Memorandum

Re: Milestone MCMC LLC Short Plat SUB21-006

Date: November 8, 2022

MILESTONE PRELIMINARY SHORT PLAT

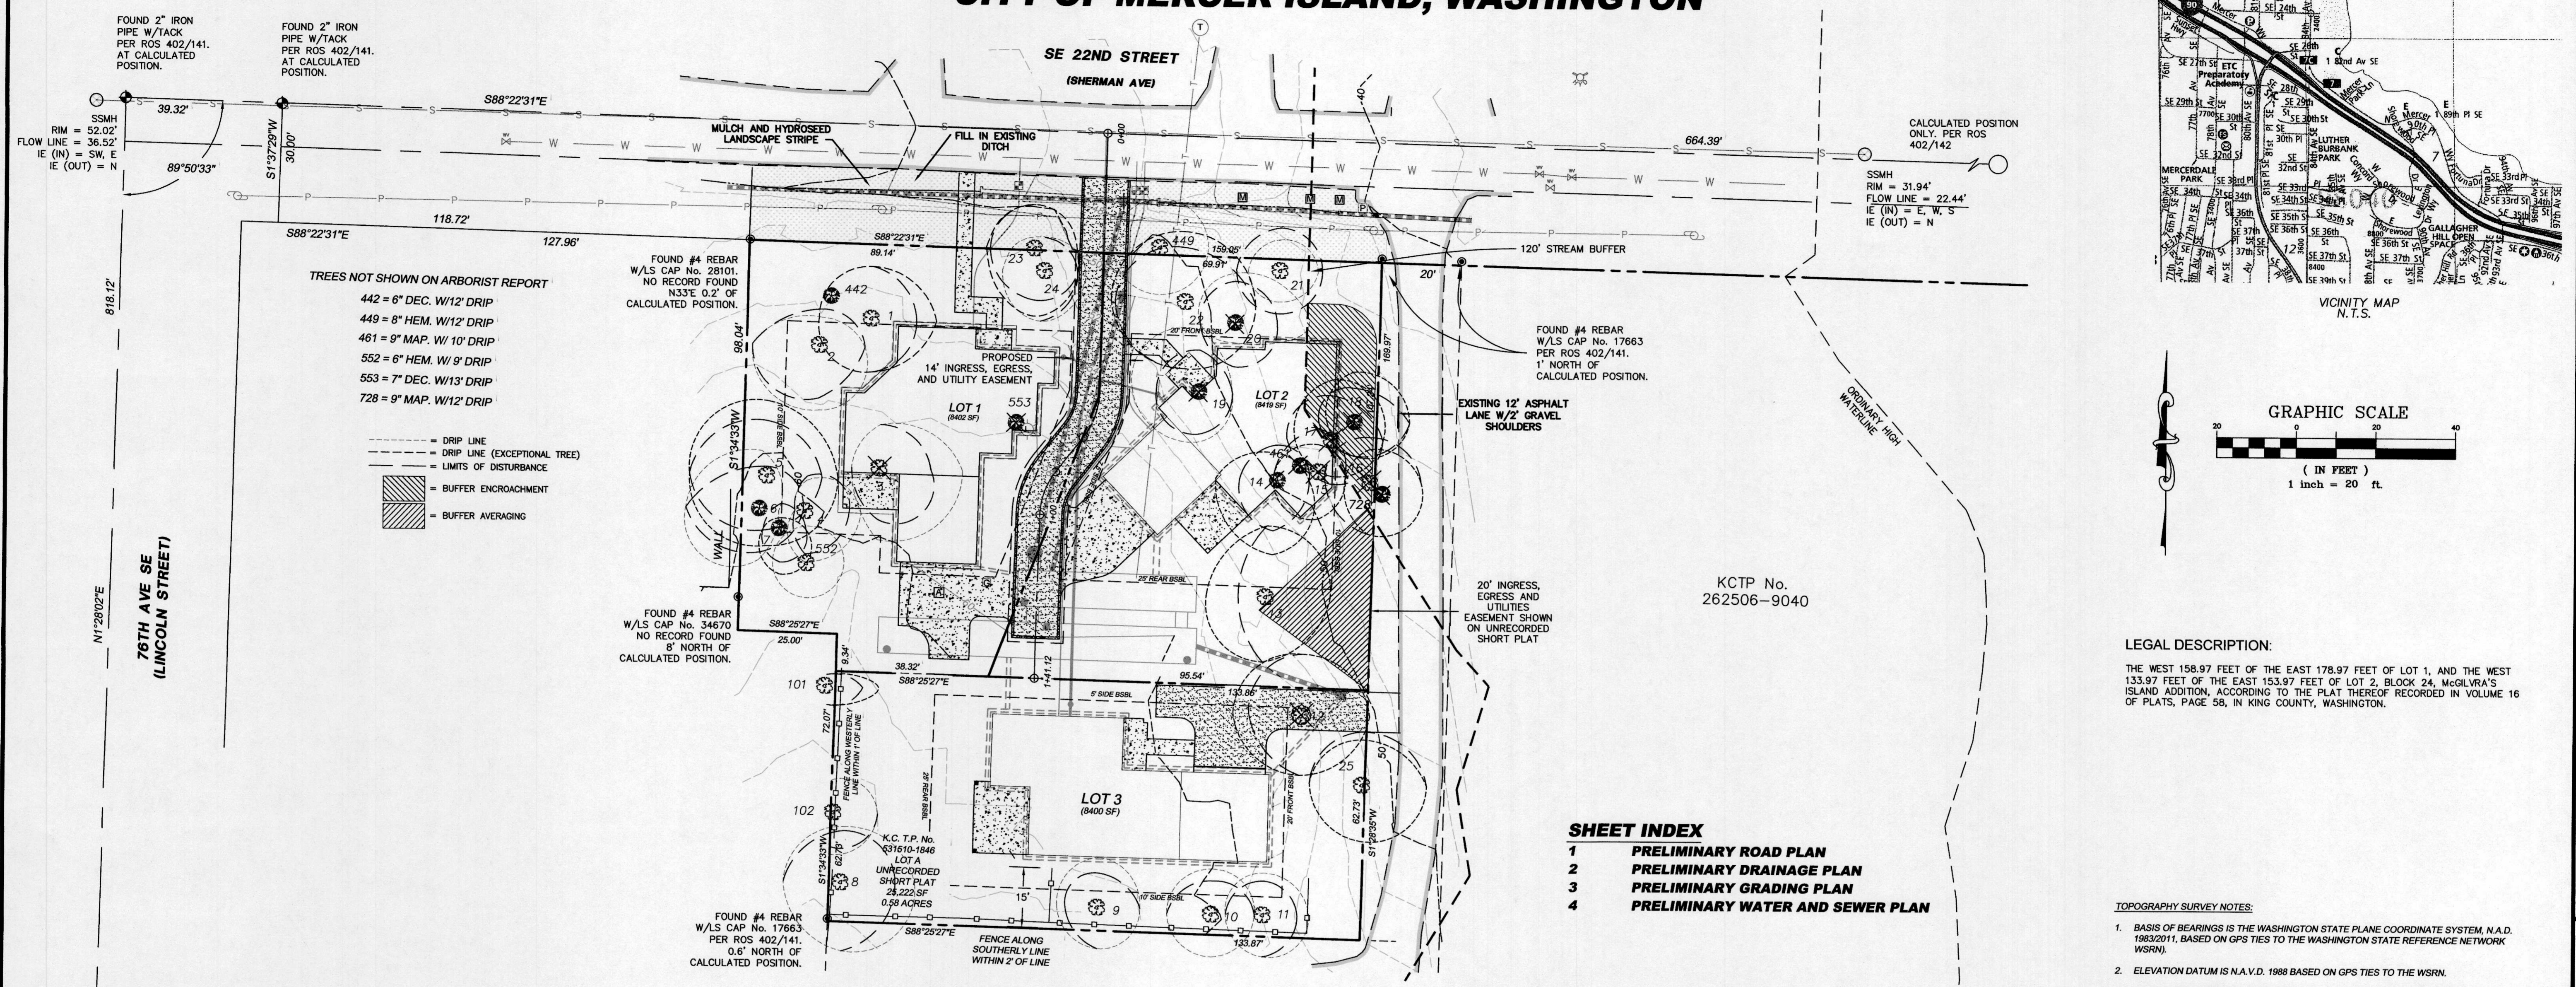
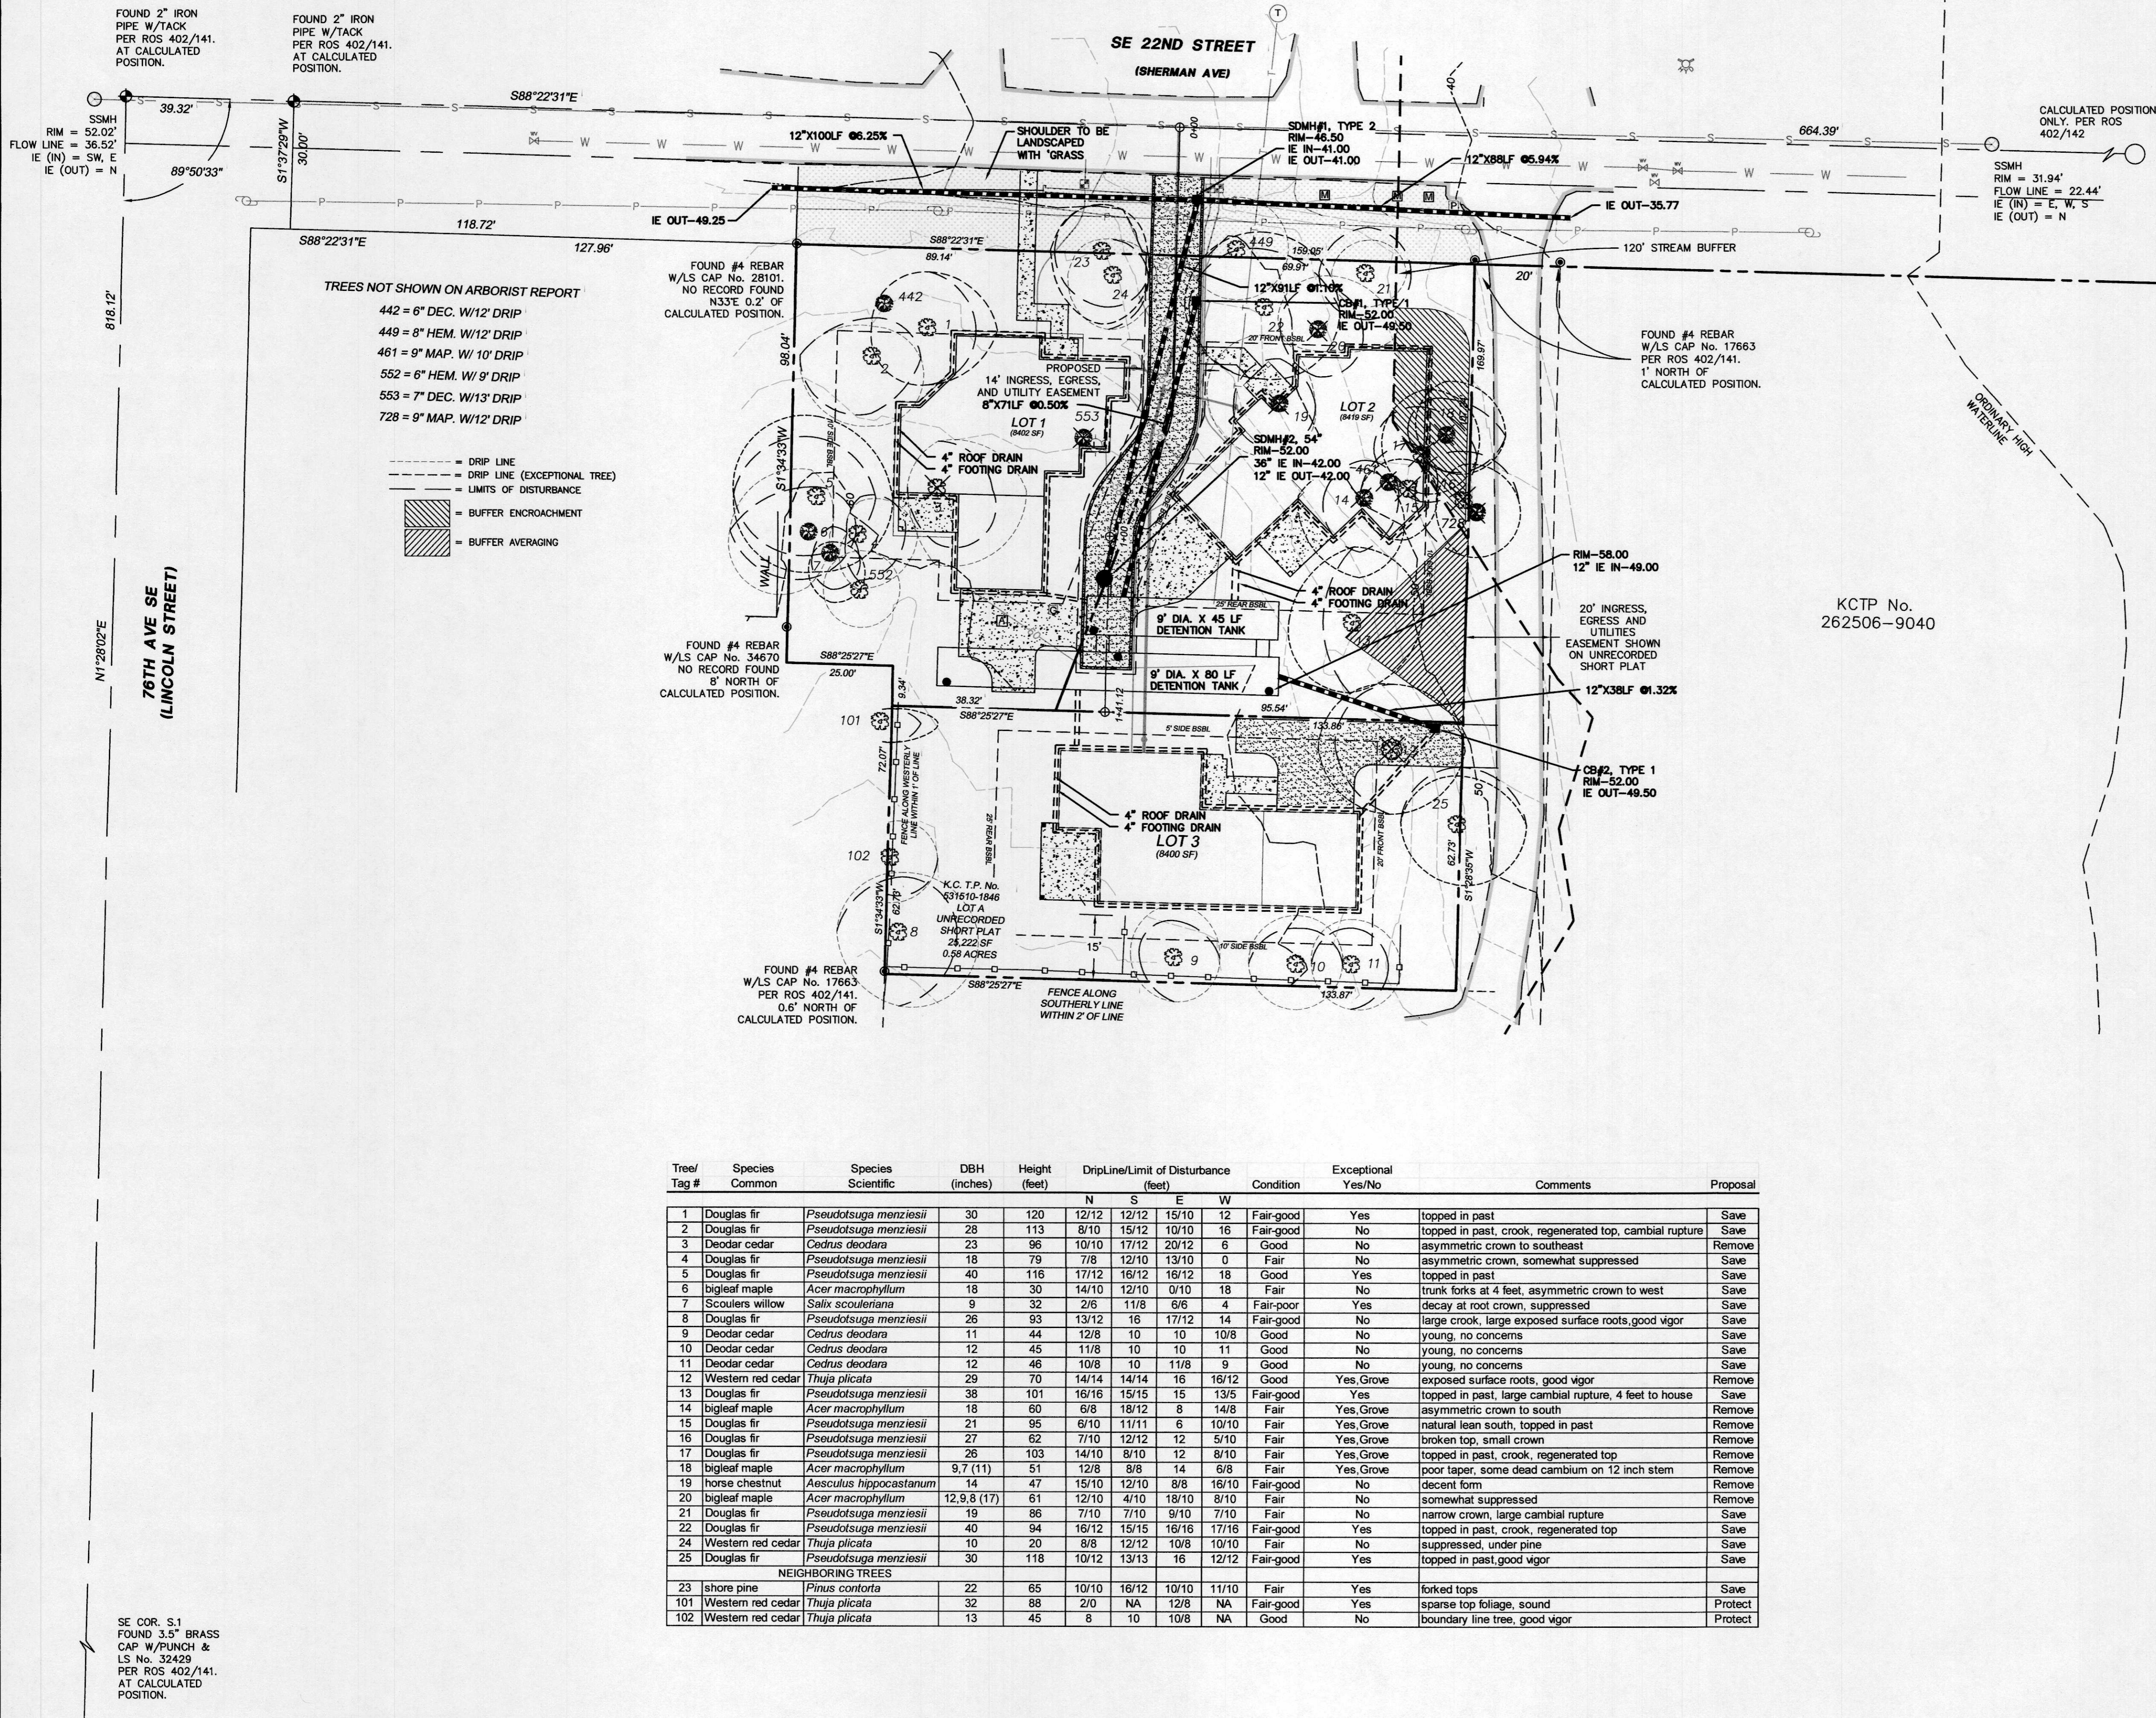
- c. Grading Plan.
 - d. Water main, water meters, and appurtenances
 - i. Provide water services for each lot. Locate water meters outside of the future driveway areas and any paved areas.

- ii. Abandon all existing water services currently serving the existing lot at the City water main.
 - e. Sanitary sewer and appurtenances
 - i. Provide sewer connections for each lot. Show the sanitary sewer stub outs for each lot.

- ii. The side sewer for all lots shall be a shared side sewer with one single connection to the city Sewer Main. The maximum number of the residences is 6 for a 6" shared side sewer.

- iii. The sanitary sewer system serving all lots will be a private sewer system.
 - f. Stormwater
 - i. Provide drainage improvements in compliance with MICC 15.09.

- ii. Show the storm drainage stub outs for all lots.
 - g. Dry utilities
 - i. Show the proposed dry (power, gas, etc.) utility corridor on the plan.
8. Right of Way Restoration
